Subject: Post Permit Revision 1 - Summary Letter

Project: 6221 83rd Pl, Mercer Island, WA 98040  
MI Project # 2207-110

**A3.1**

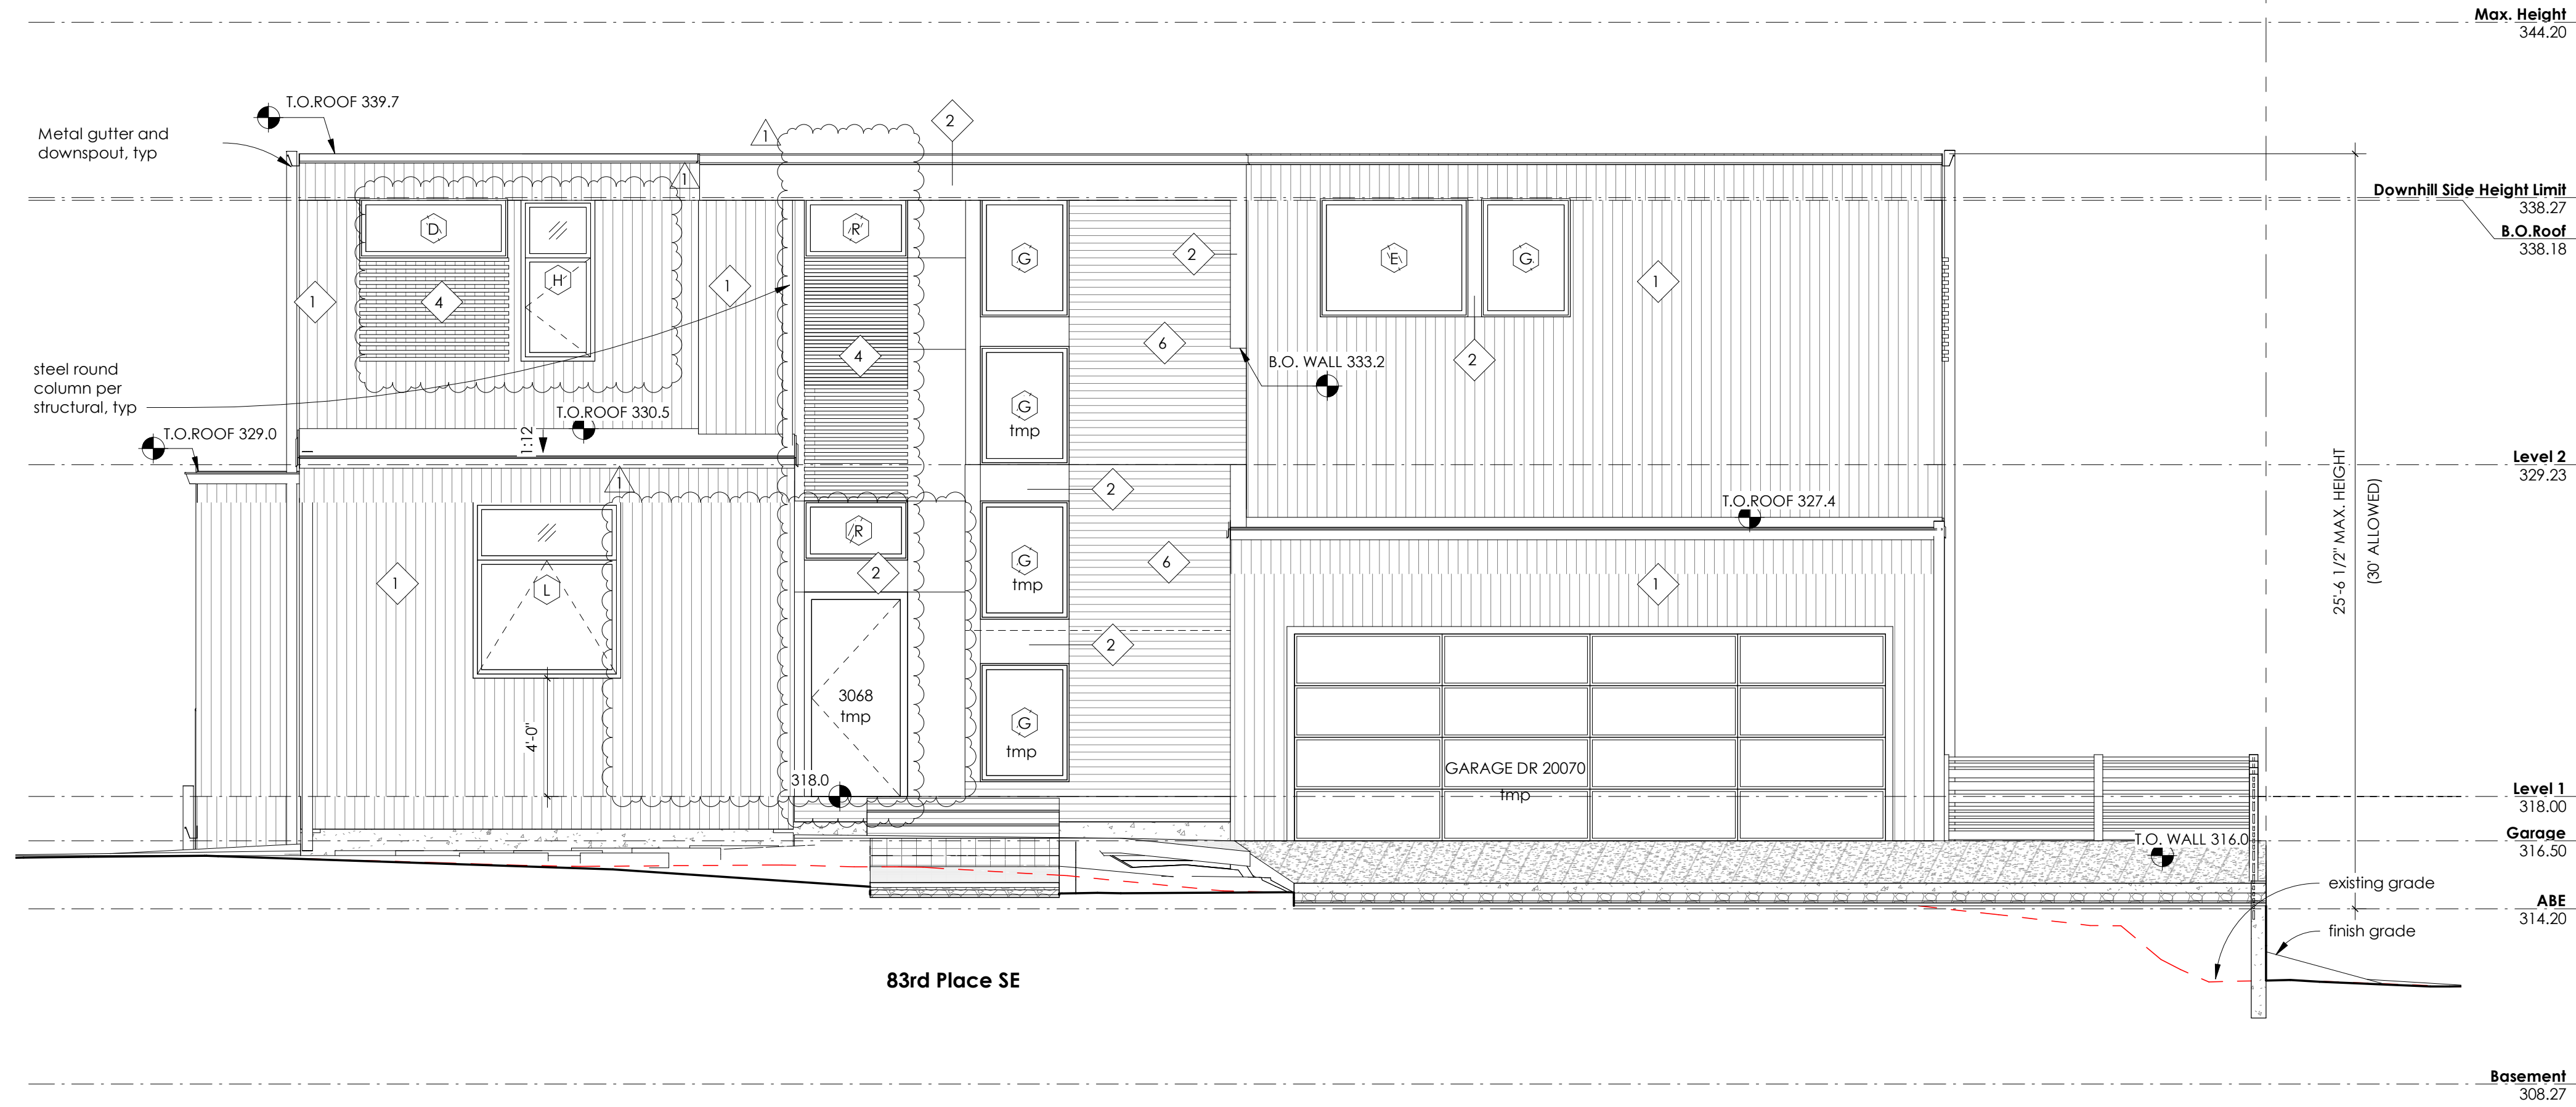
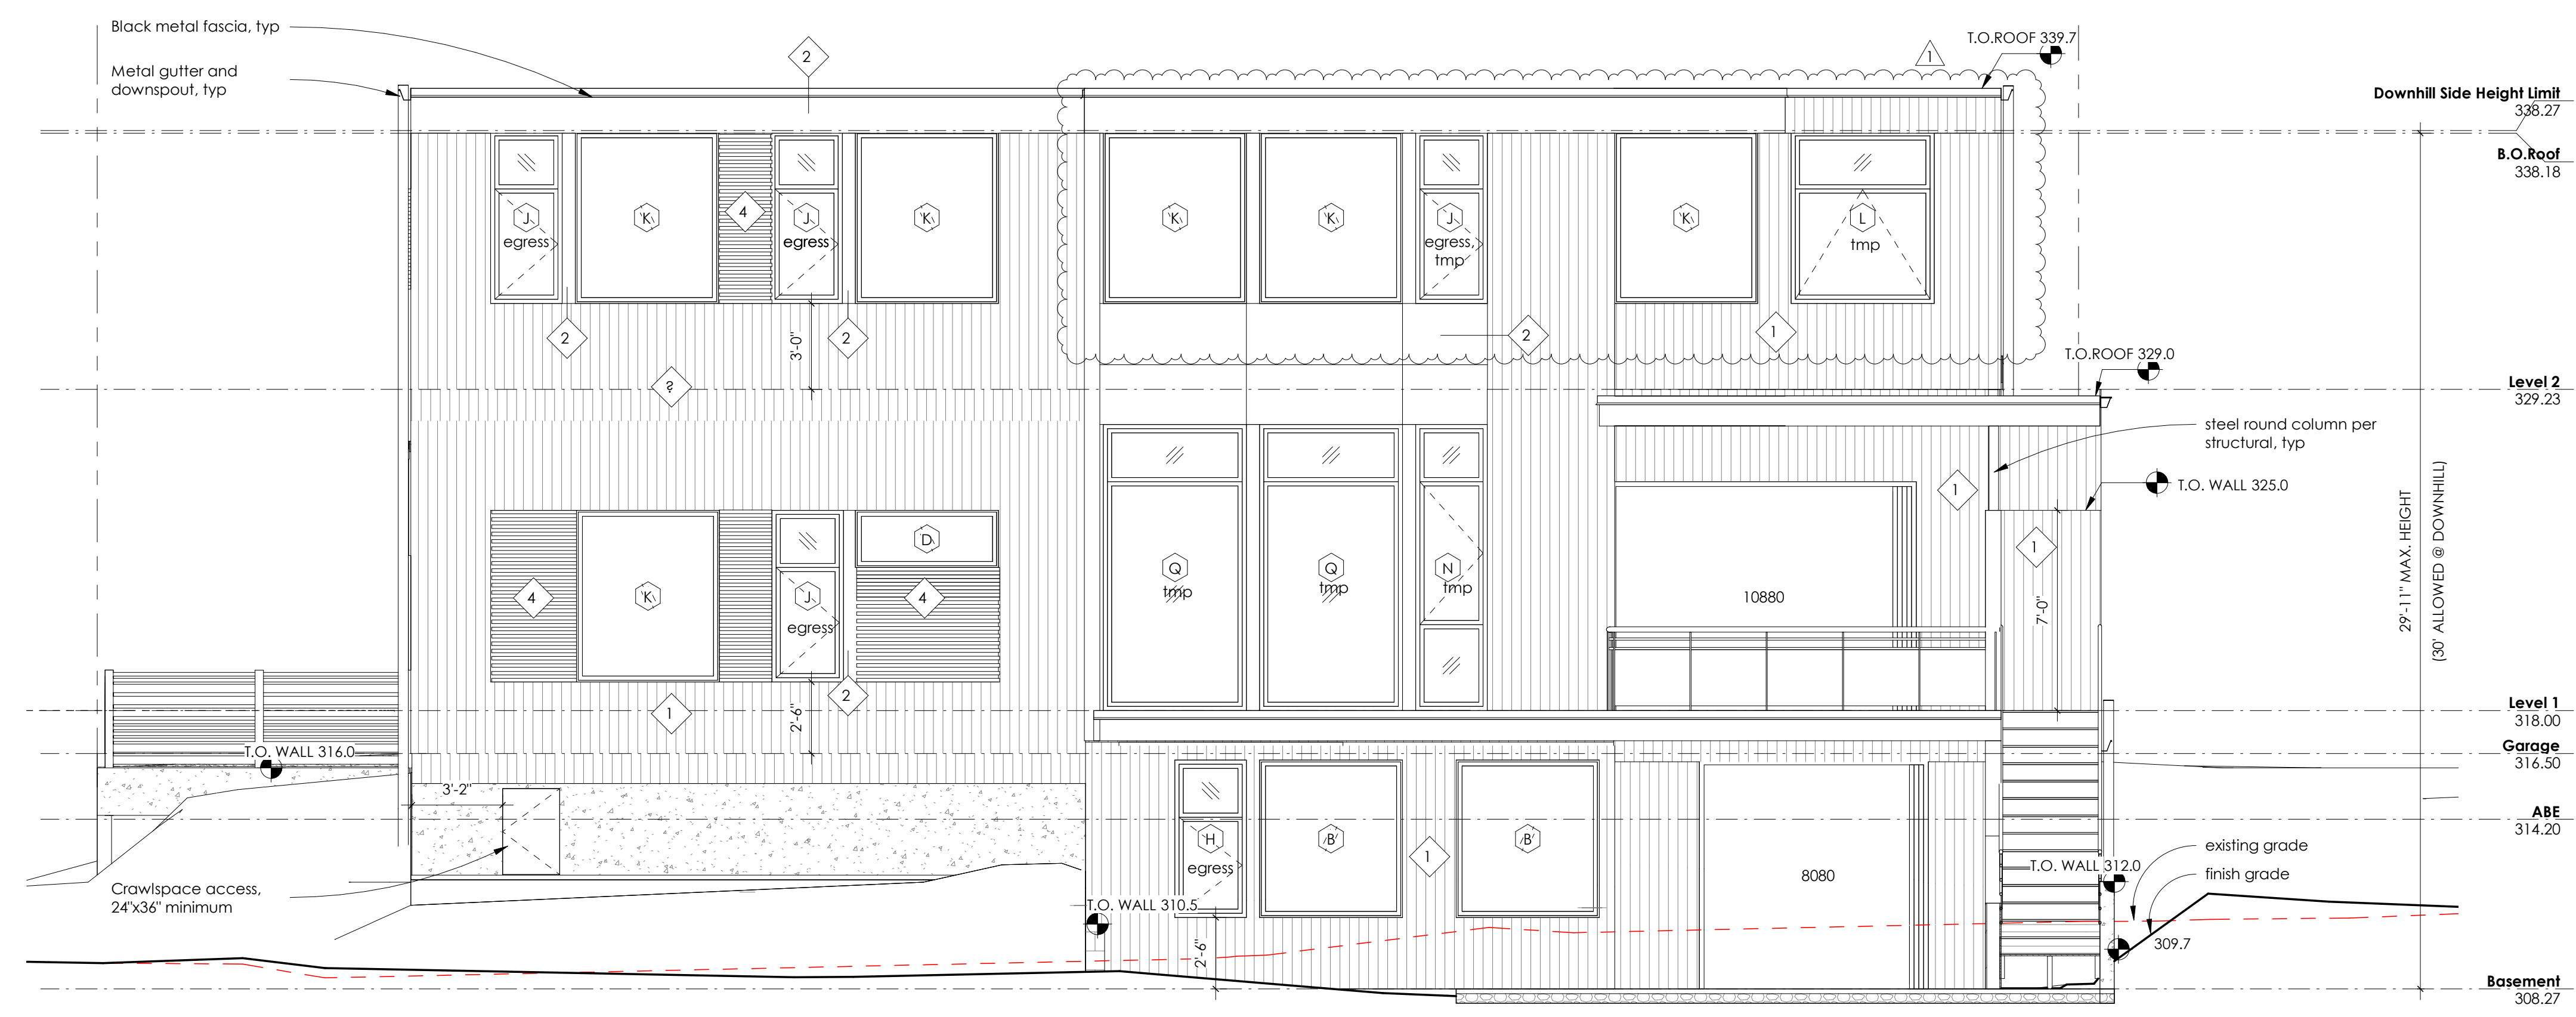
- A2.4 – Roof Level – Revised for enlarged master bathroom
- A3.1 – Elevations – Entry door and windows above, windows at master bathroom
- A3.2 – Elevations – Garage door, window revisions at master bathroom, kitchen, and living room

**A4.2**

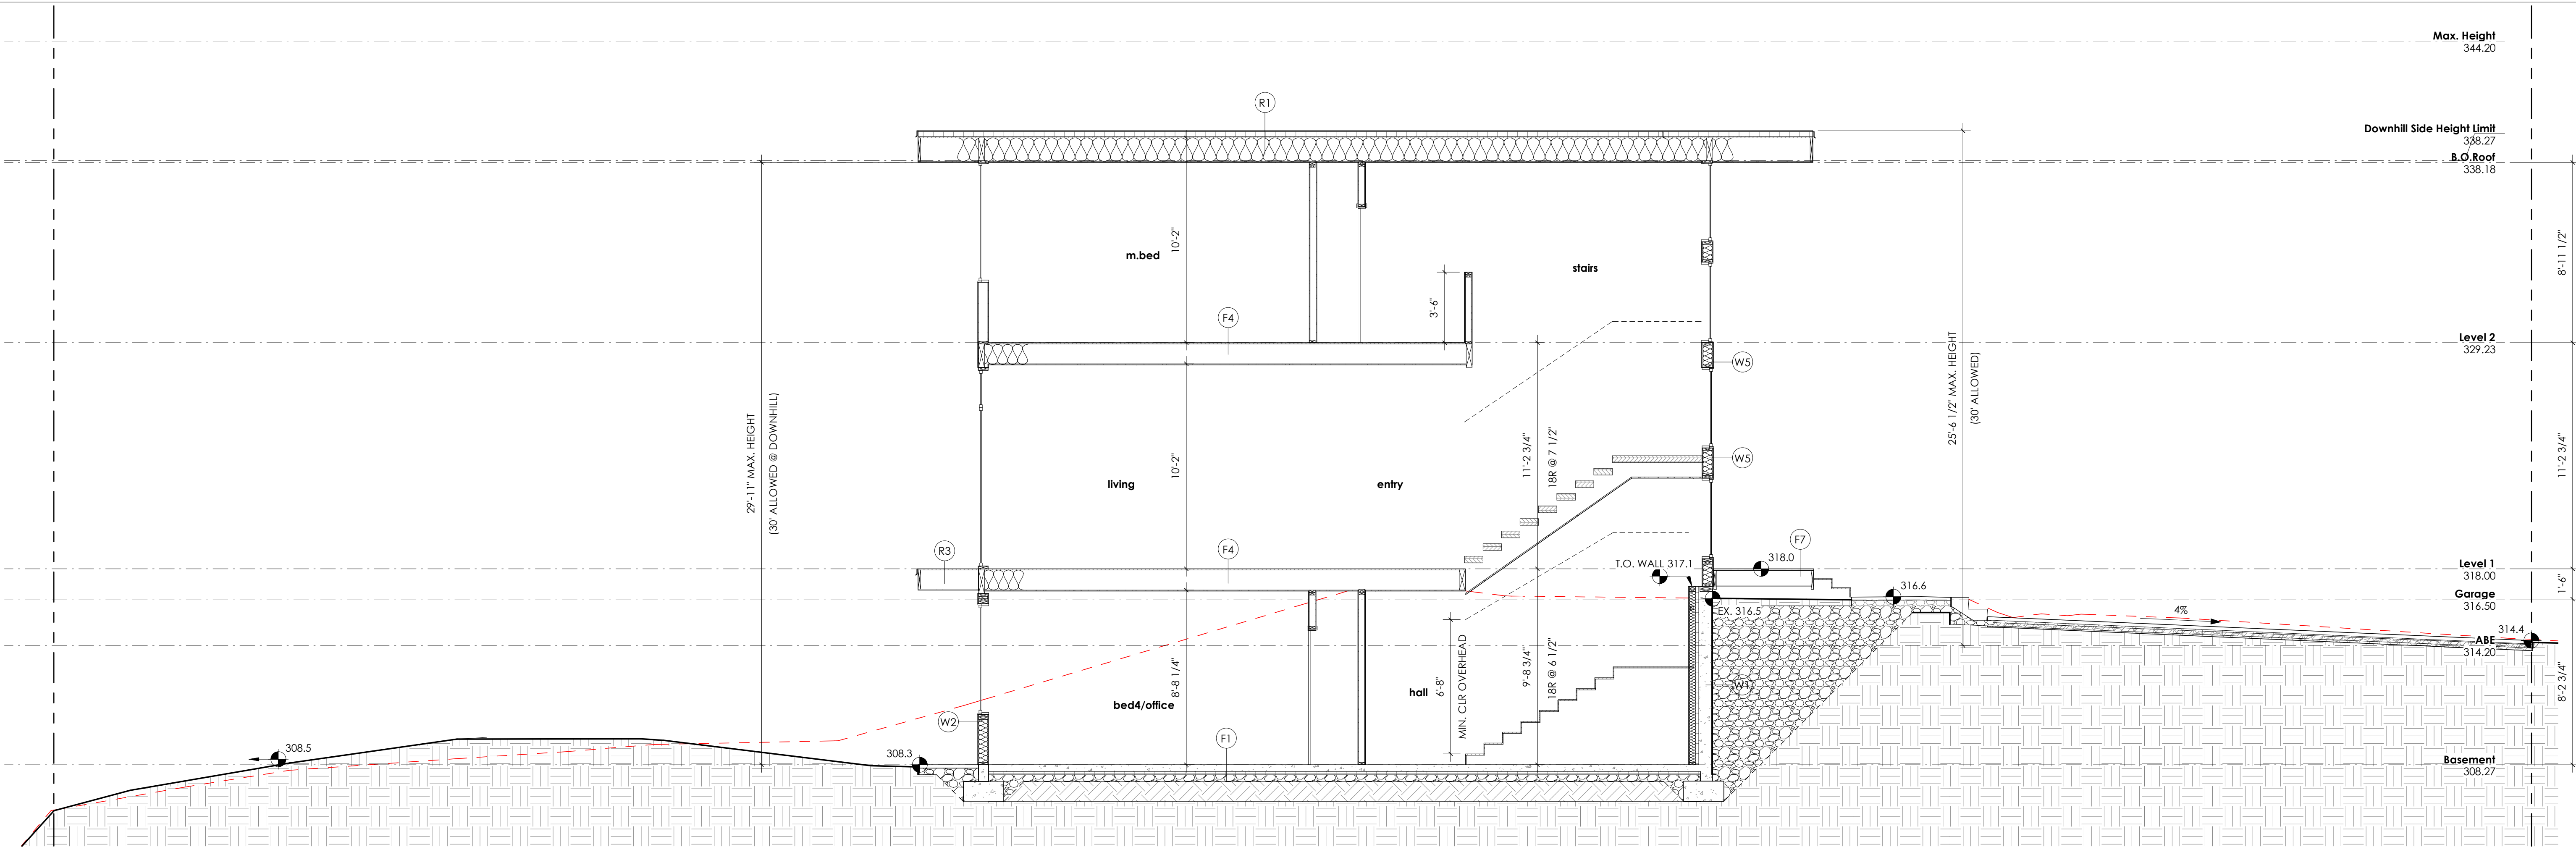
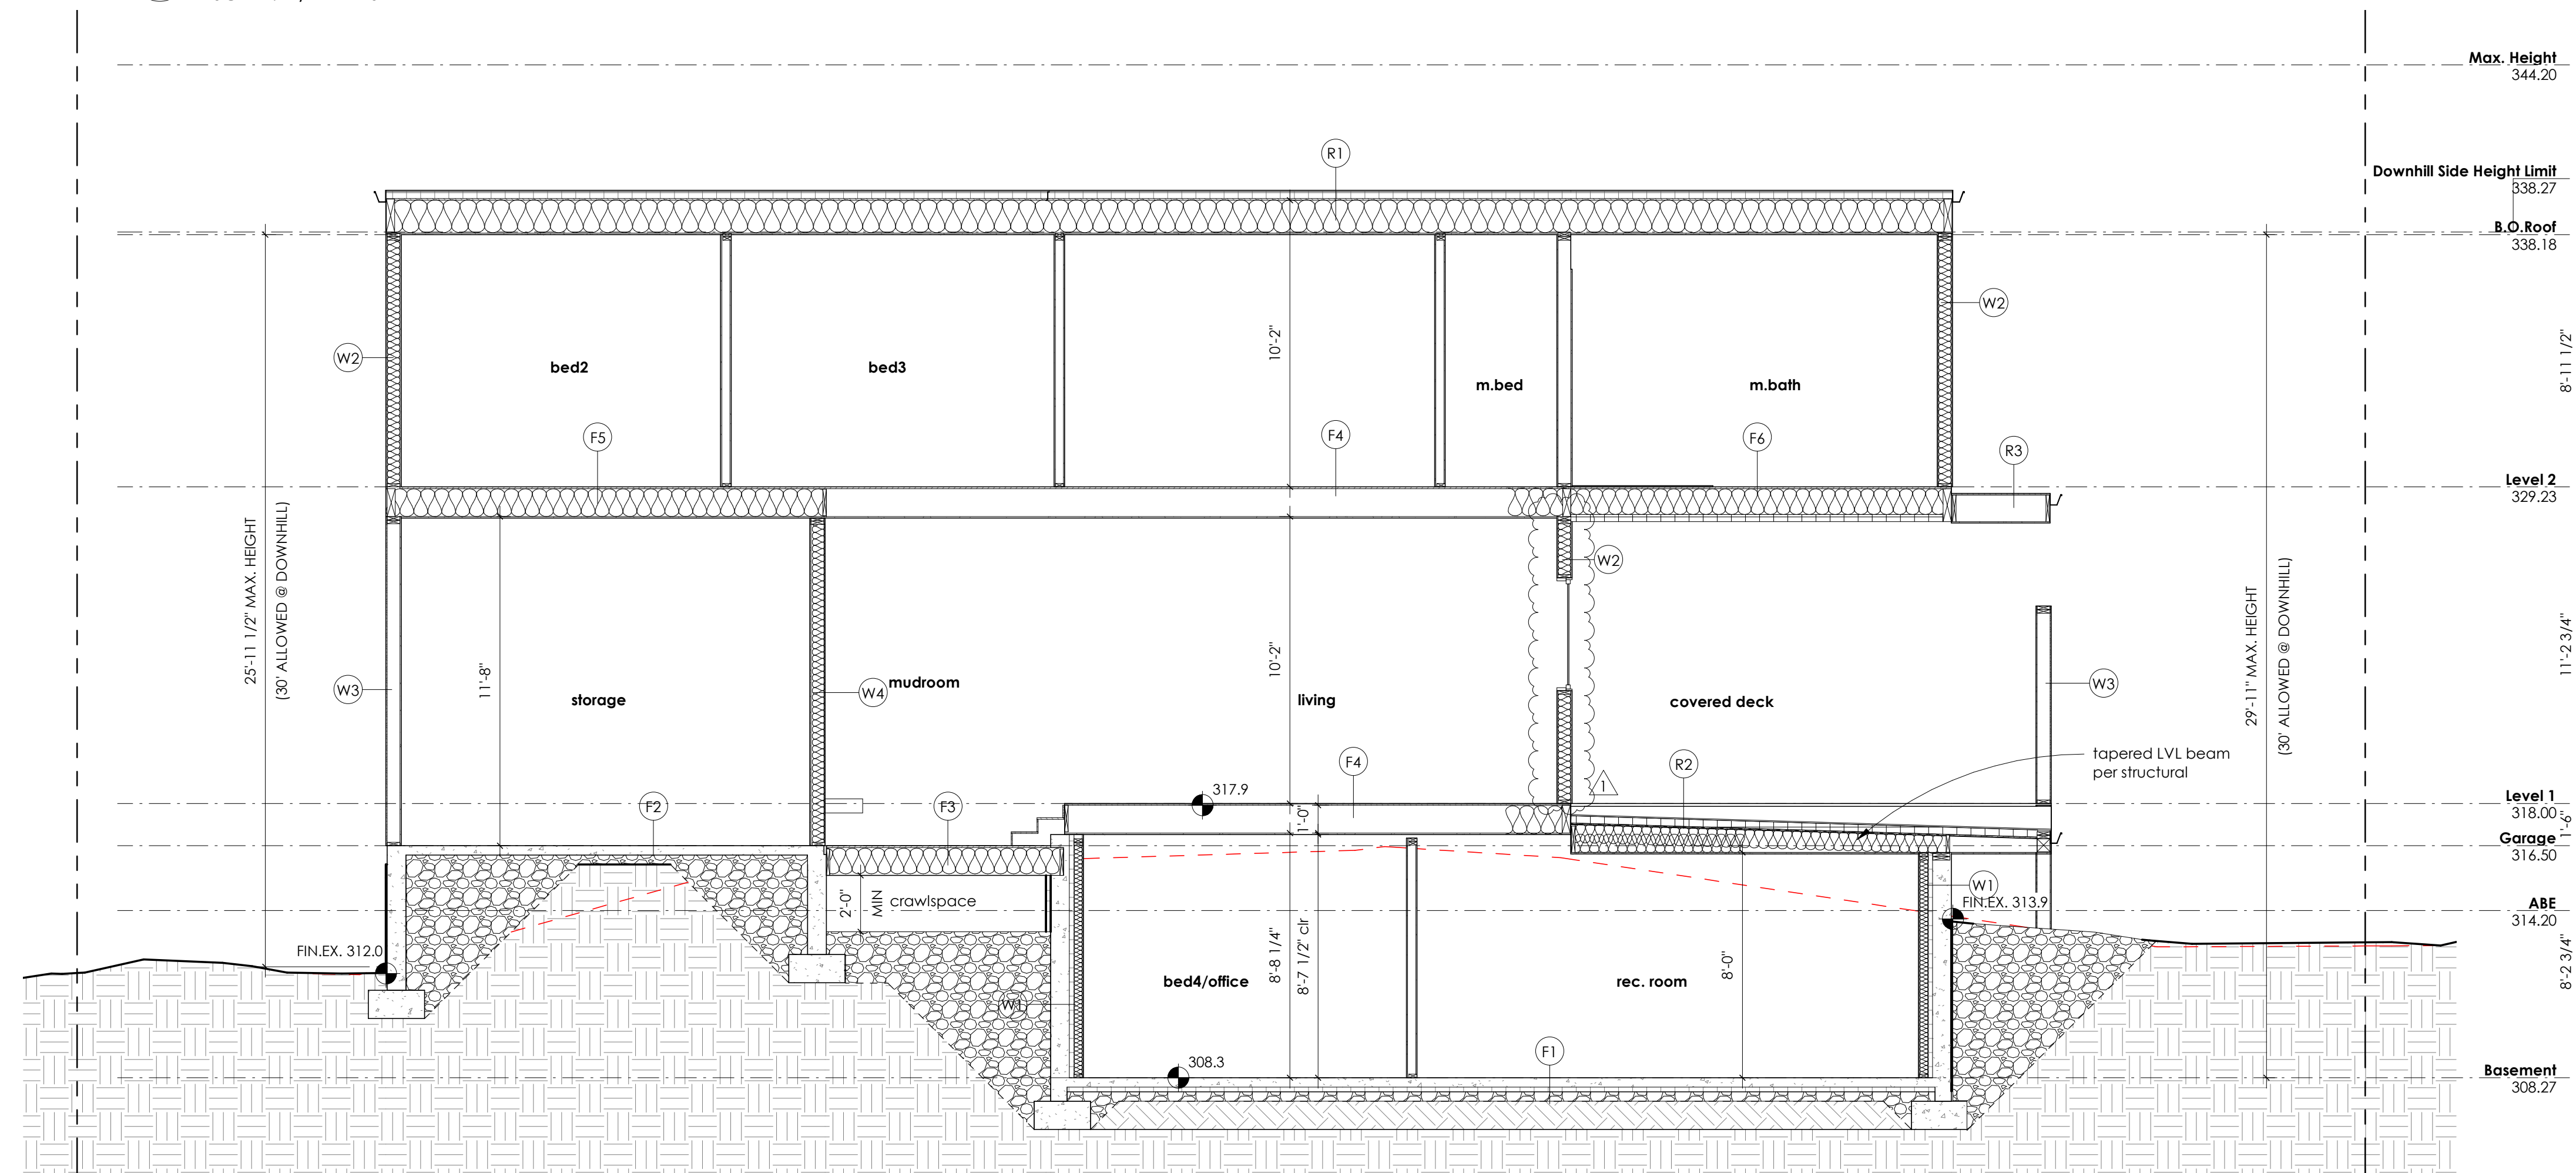
- A4.0 – Glazing – Windows R and T
- A4.1 – Assemblies – F4 thickness revised
- A4.2 and A4.3 – Sections – Window revision and width of master bathroom
- S2.1 – S2.4 – Plans reflect architectural changes
